Mellor Parish Council

**Planning Application 3/2020/1061 Pendle View, Primrose Lane, Mellor BB2 7EQ
Proposed erection of a seven bedroom holiday cottage.**

Title: Proposed Plans and Elevations.

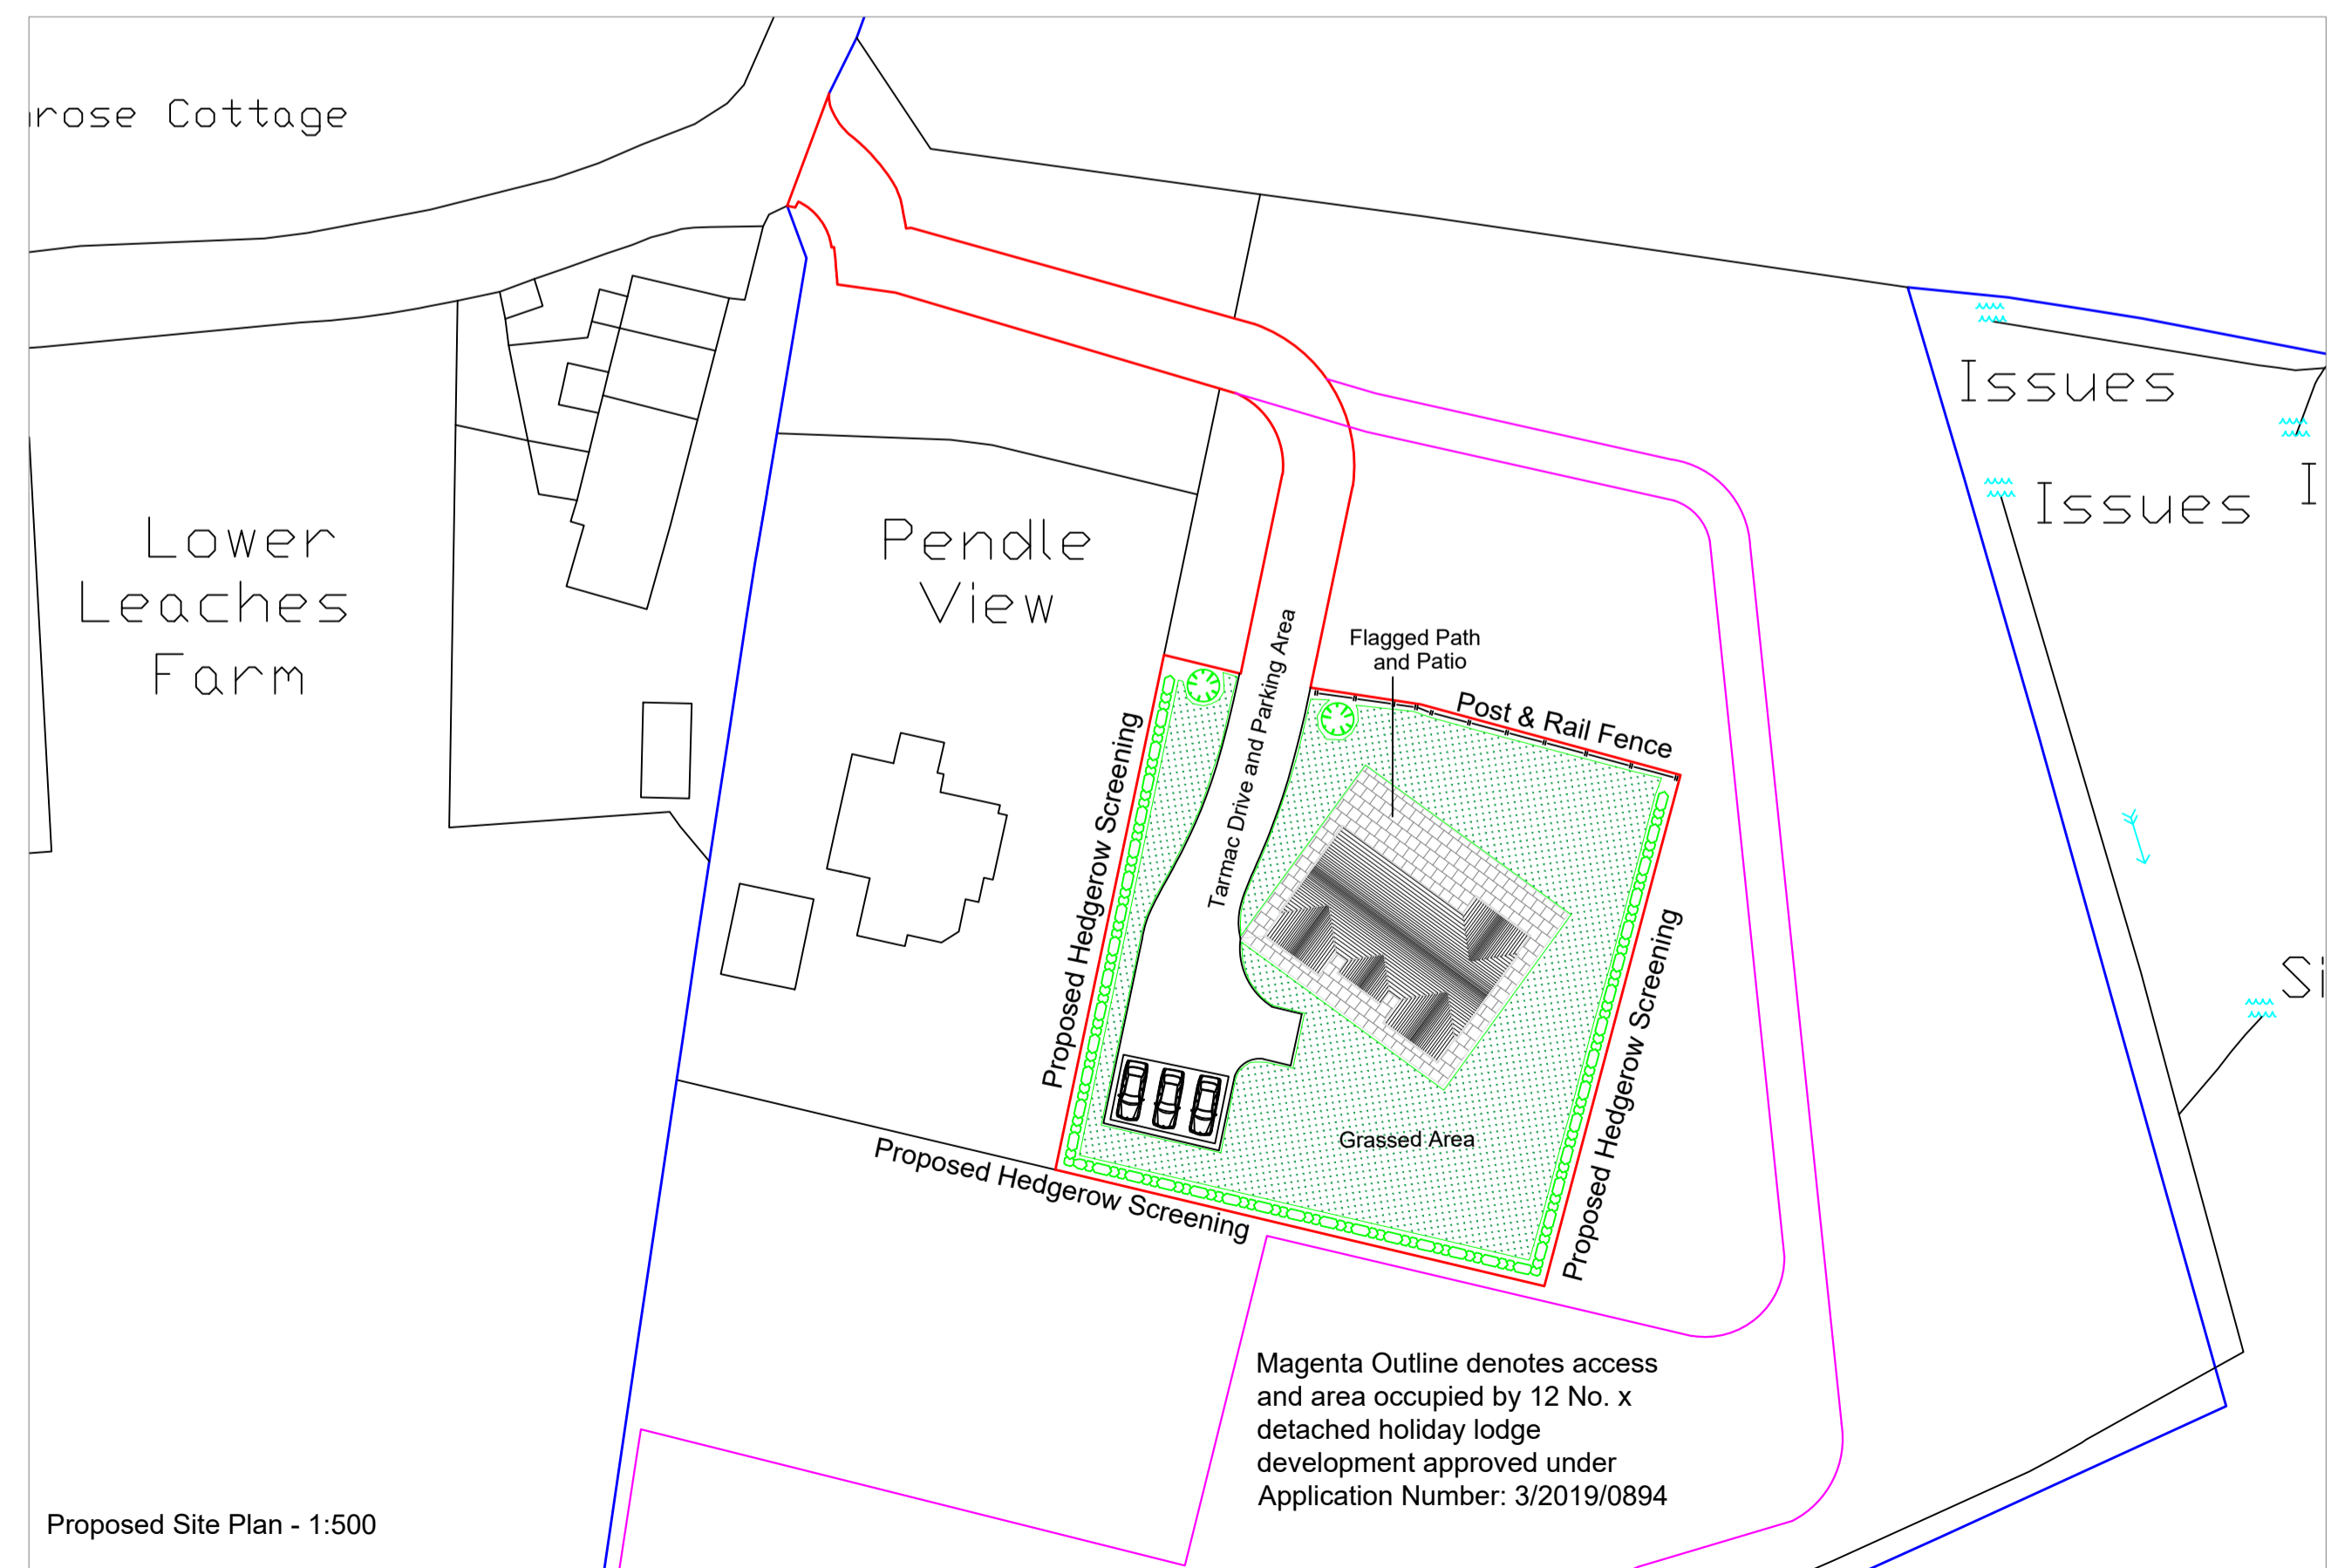
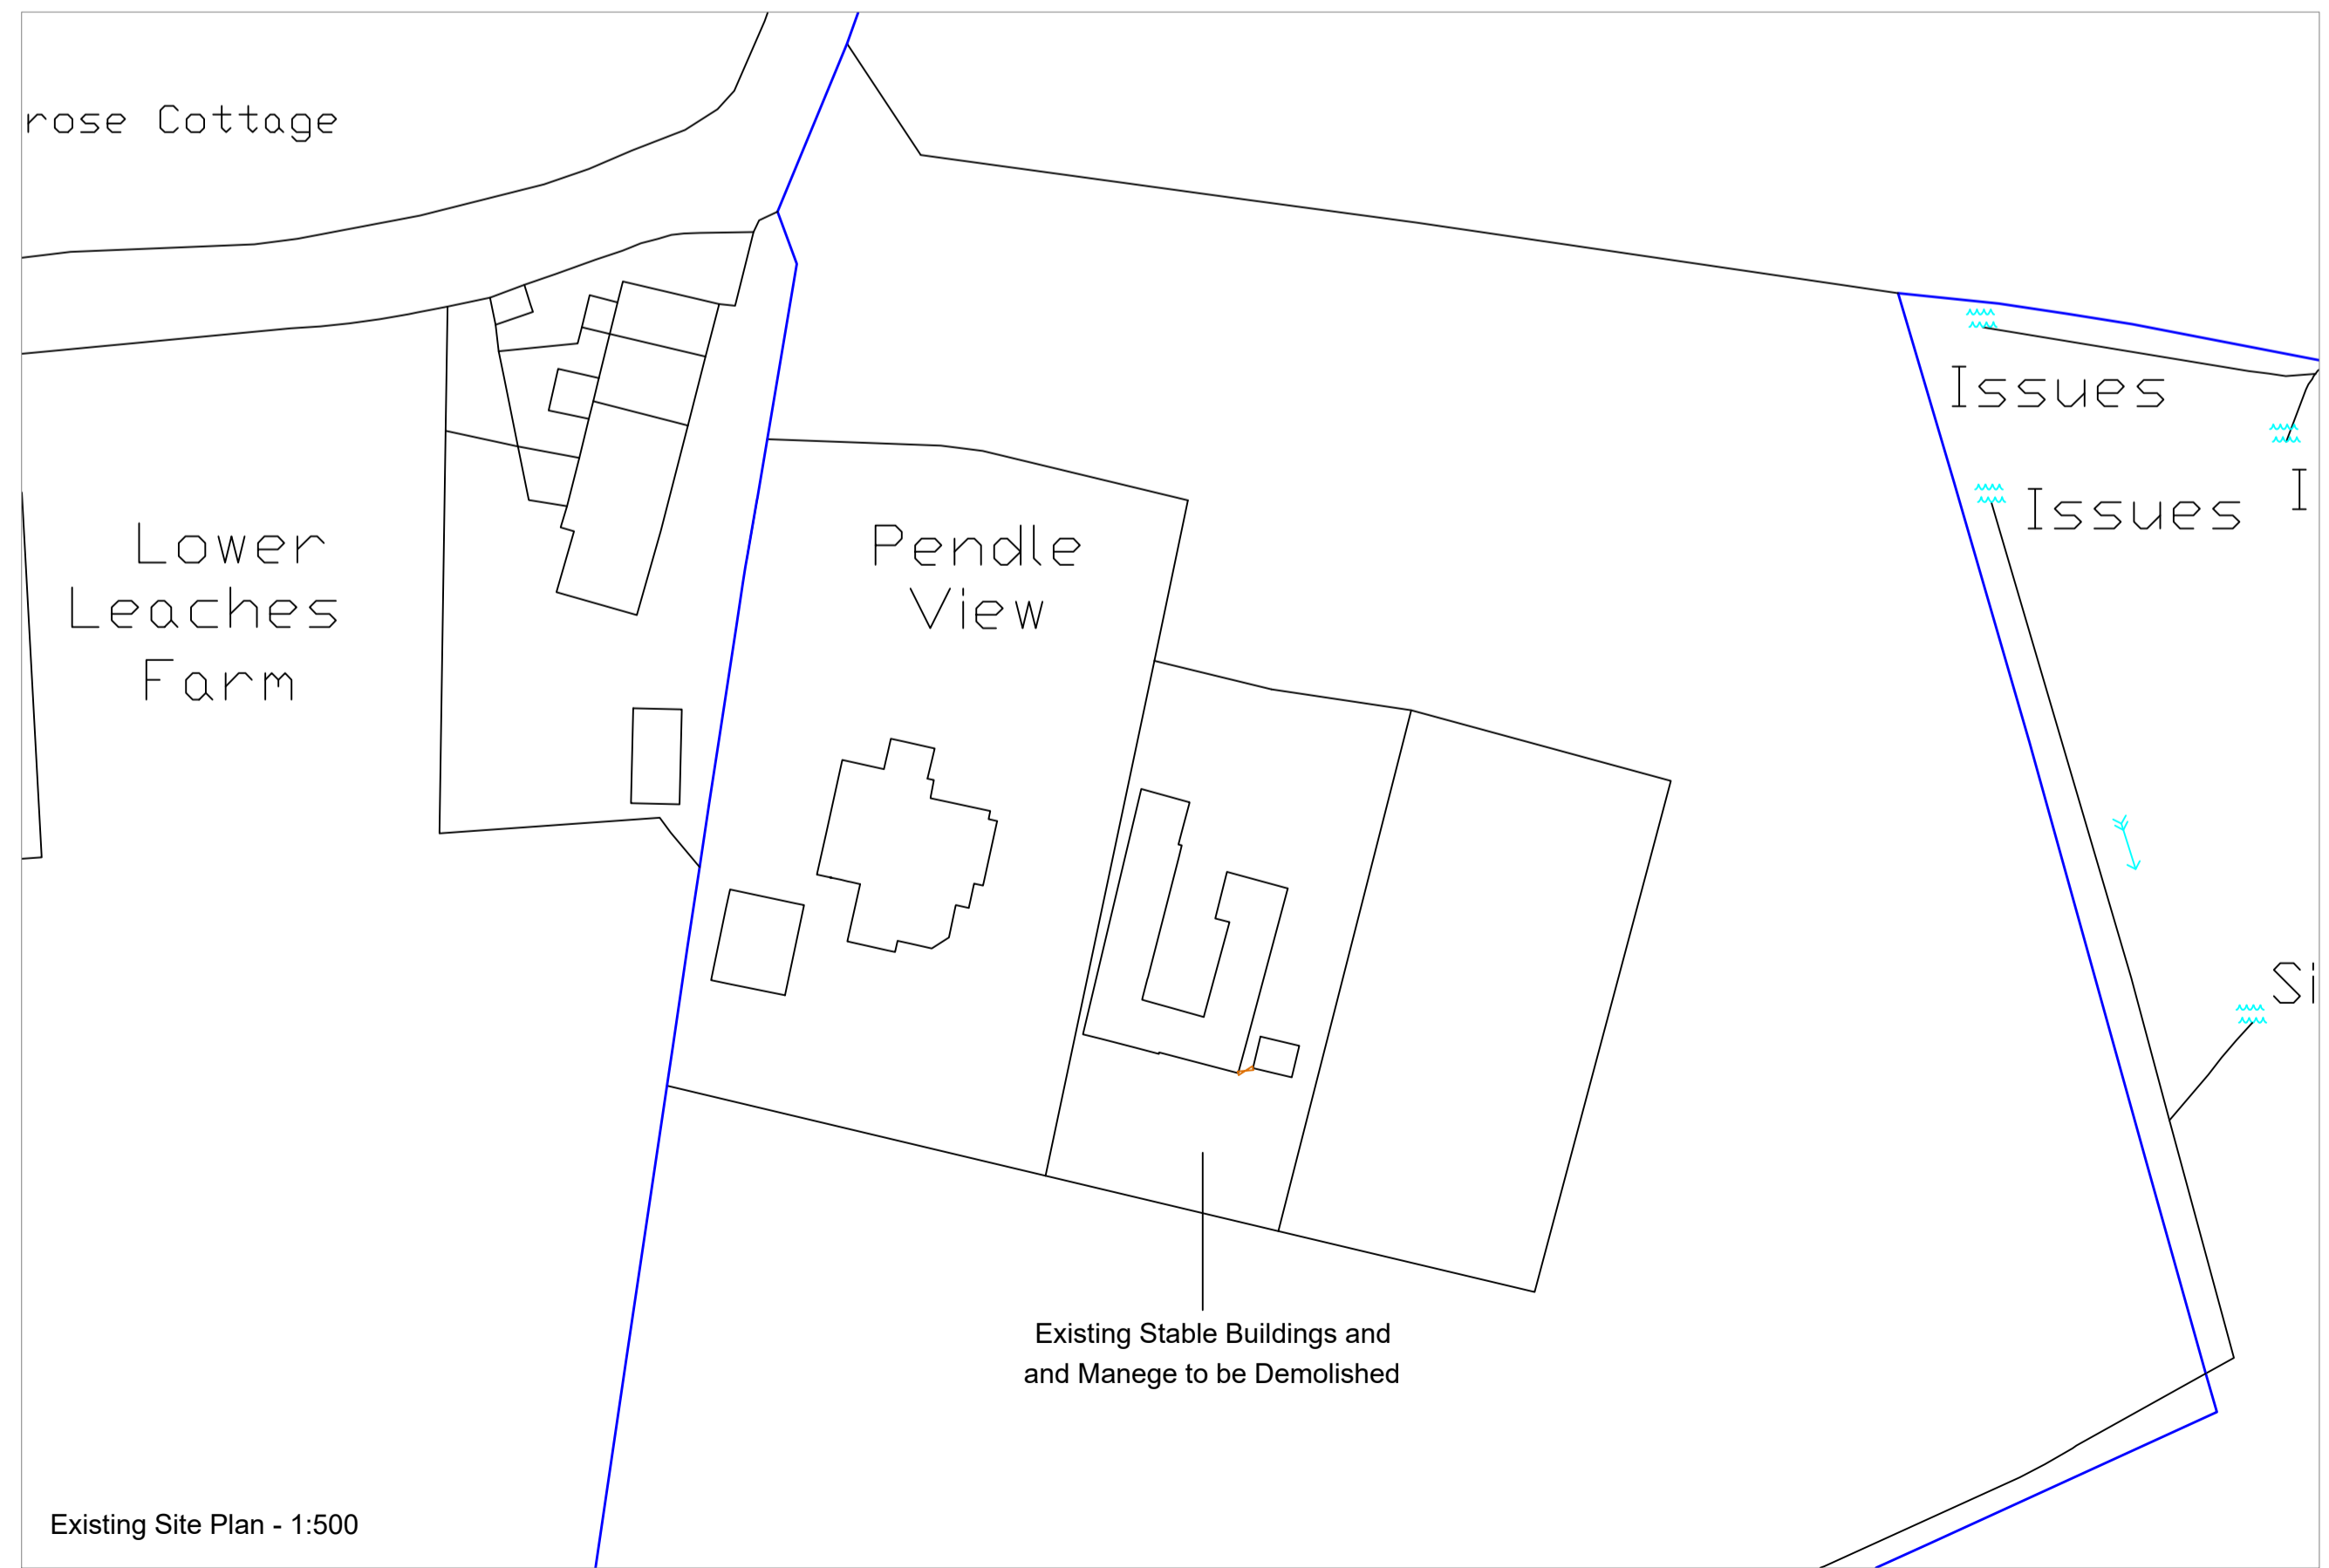
- 7 bedrooms (1 downstairs) but only 2 bathrooms upstairs & 1 downstairs wet room suggests a residence design rather than a holiday cottage. Parish Council asks for an imposed condition that this not be allowed change of use to permanent residence

- New build design in brick is not in keeping with locality inc. visually within the rural landscape
- Parish Council submits that other holiday cottage approvals in Ribble Valley noted in the Planning Statement are irrelevant to this application, especially as there is no supporting evidence of additional need at this site, which is at a greater distance from local amenities than most of those quoted
